CITY OF MERCER ISLAND

RE: Request for Information – SUB18-008

The City of Mercer Island Community Planning and Development Department has completed its review for compliance with the zoning code, Title 19 of the Mercer Island City Code (MICC) for the preliminary short subdivision application submitted on December 3, 2018, located near 3633 90th Ave SE. The following issues need to be addressed before we can continue processing the application:

SITE PLAN

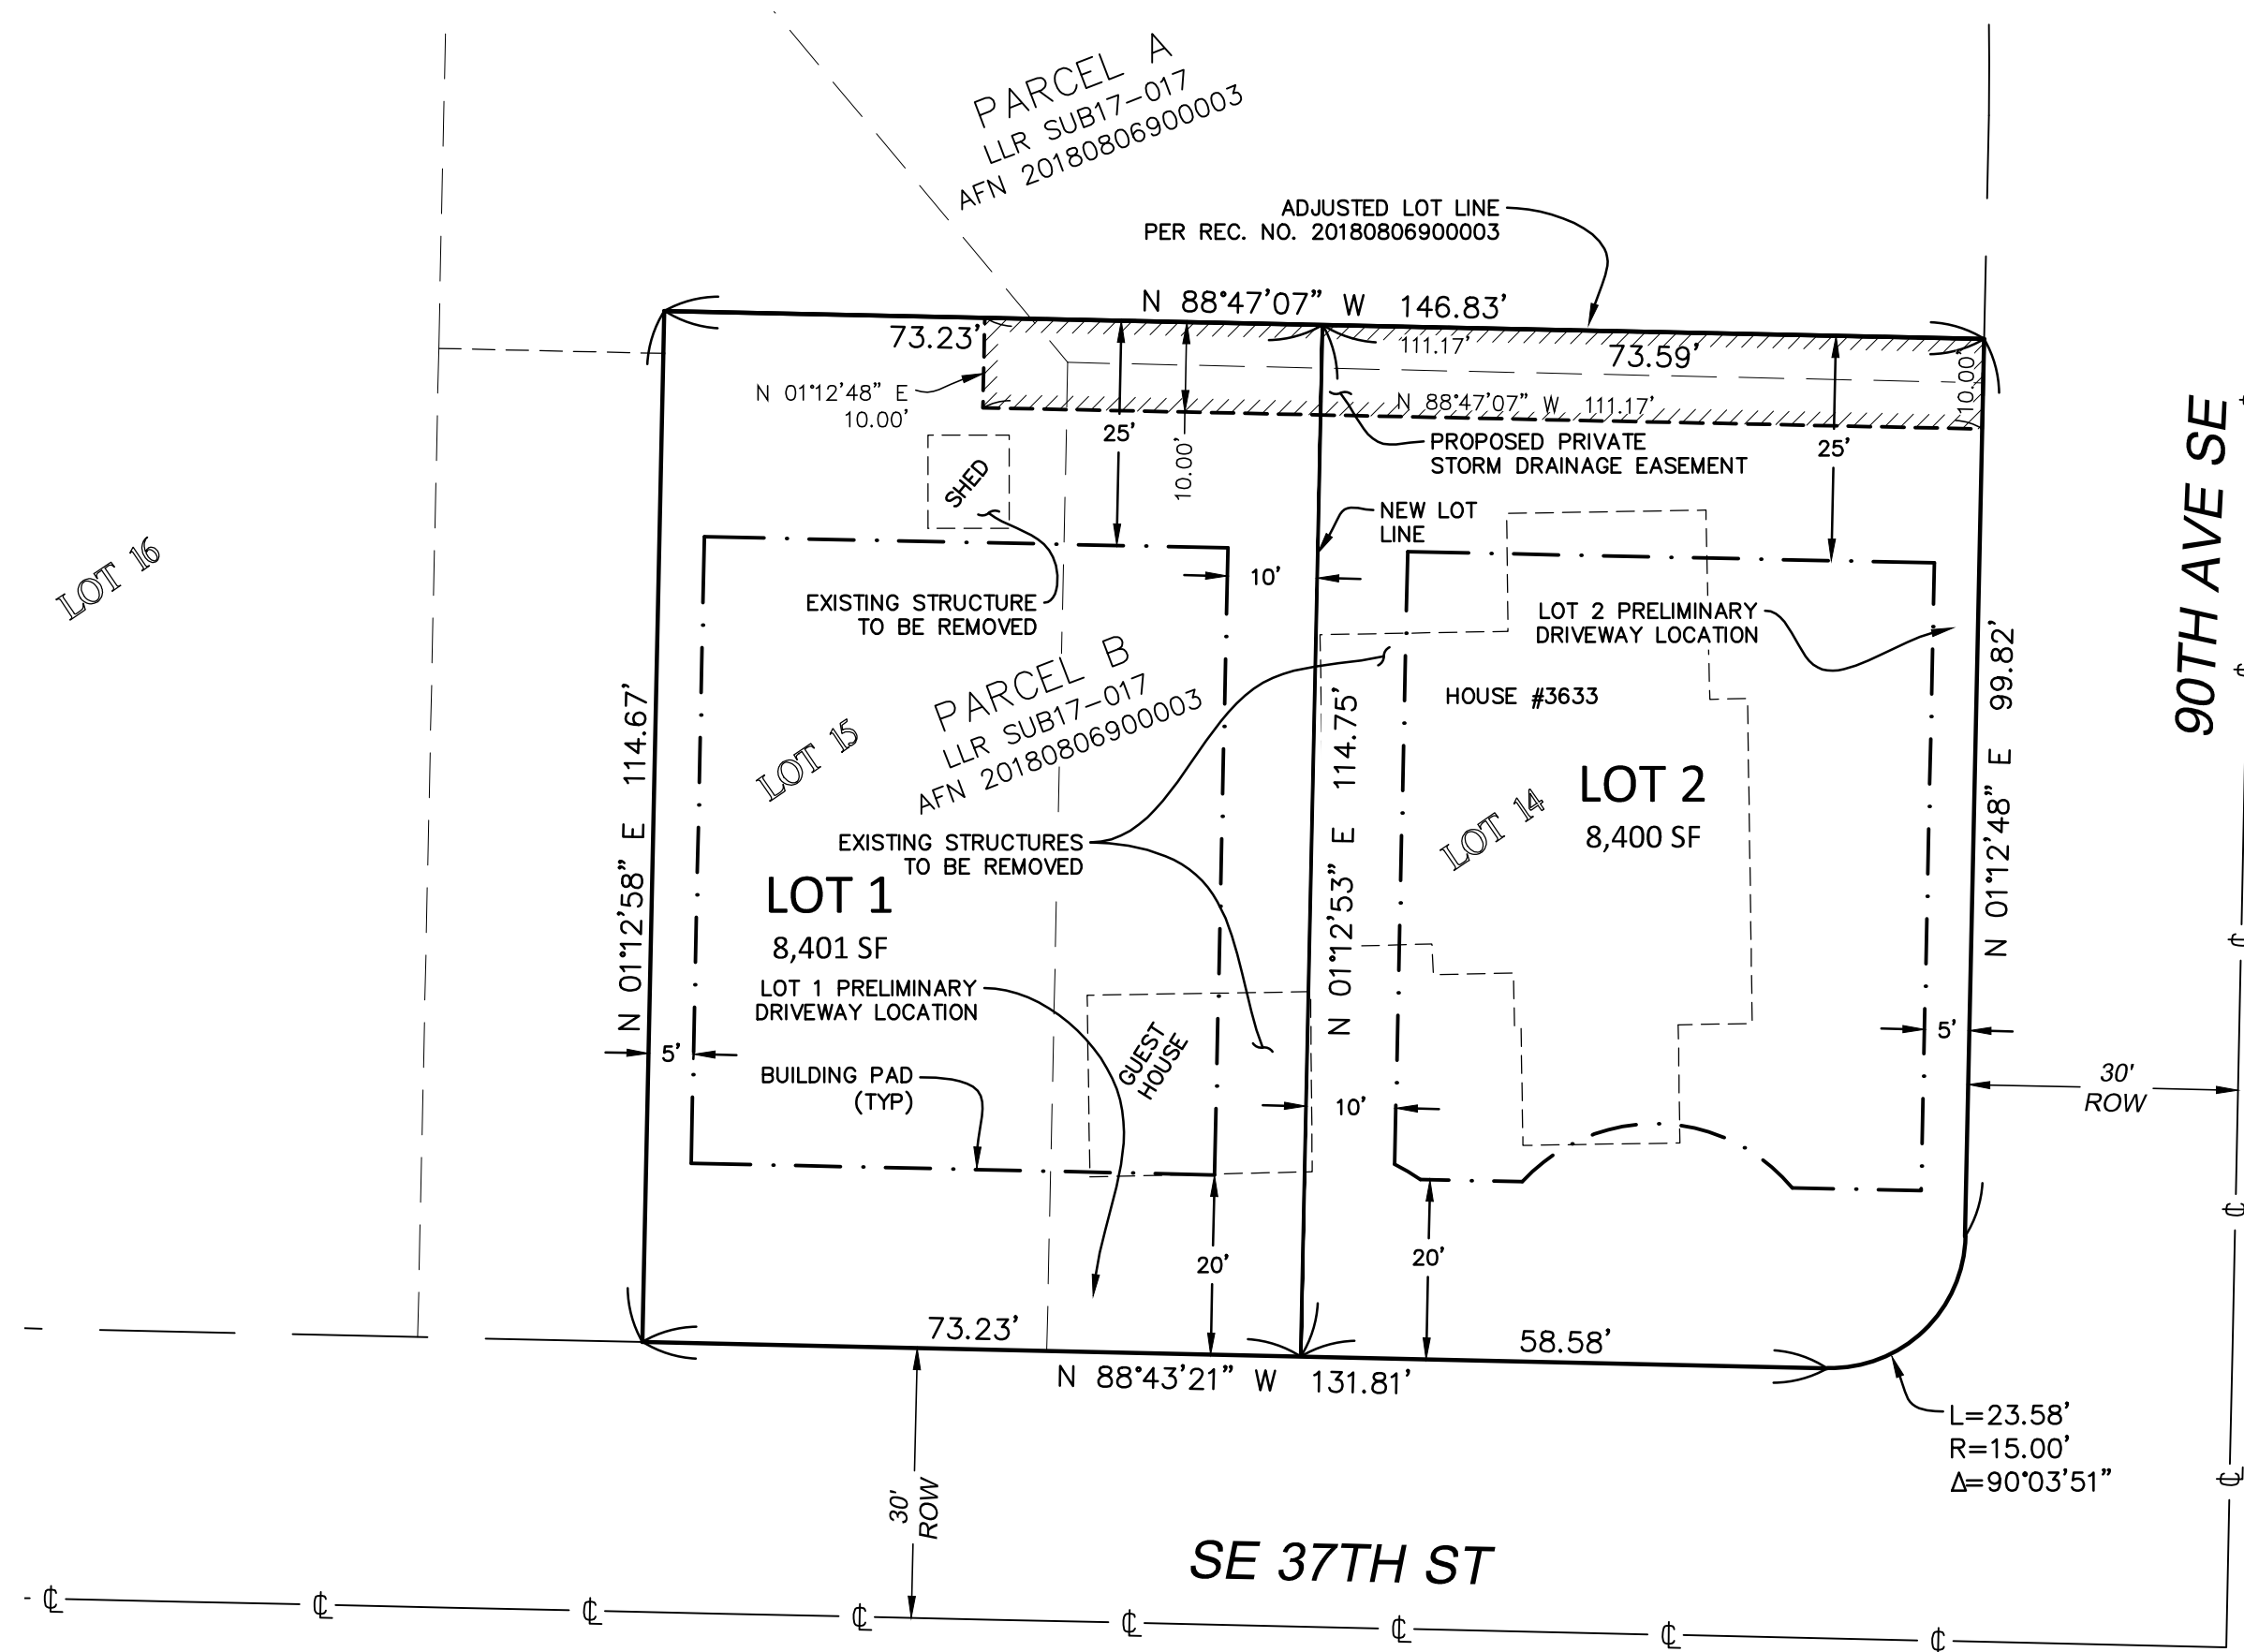
1. MICC 19.08.030(E)(4) states that proposed subdivisions shall incorporate preferred development practices pursuant to MICC 19.09.100 where feasible. MICC 19.09.100(A) requires that development, including subdivisions, shall use common drives and utility corridors where feasible.

The project narrative states that Lots 1 and 2 will access different streets, at opposite corners of the parent lot. The narrative further states that alternate options for a shared drive were explored, but abandoned since they would either impact retained trees or would result in additional impervious surface. Based on the plans, there appears to be sufficient space either on the north side of both lots or along the proposed property line dividing lots 1 and 2 to construct a driveway without impacting trees. The addition of impervious surface coverage for a shared access drive does not mean that a shared access drive is infeasible for the project.

None of these situations are present on this site. If there are other underlying issues that would result in a shared access drive being infeasible for this project, please describe them in a revised narrative.

THE ACCESS DESIGN CONFIGURATION FOR THIS SHORT SUBDIVISION HAS BEEN REVISED TO REFLECT A 20' WIDE SHARED DRIVEWAY ACCESSING OFF SE 37TH ST. A PROPOSED 20'X25' SHARED DRIVEWAY EASEMENT HAS BEEN ADDED TO THE PRELIMINARY SHORT PLAT PLAN SET TO ALLOW BOTH LOTS TO ACCESS THIS DRIVEWAY.

AN UPDATED NARRATIVE, REVISED PRELIMINARY SHORT PLAT PLAN AND UPDATED CIVIL PLAN SHEET ARE INCLUDED IN THIS SUBMITTAL FOR REVIEW. THANK YOU.
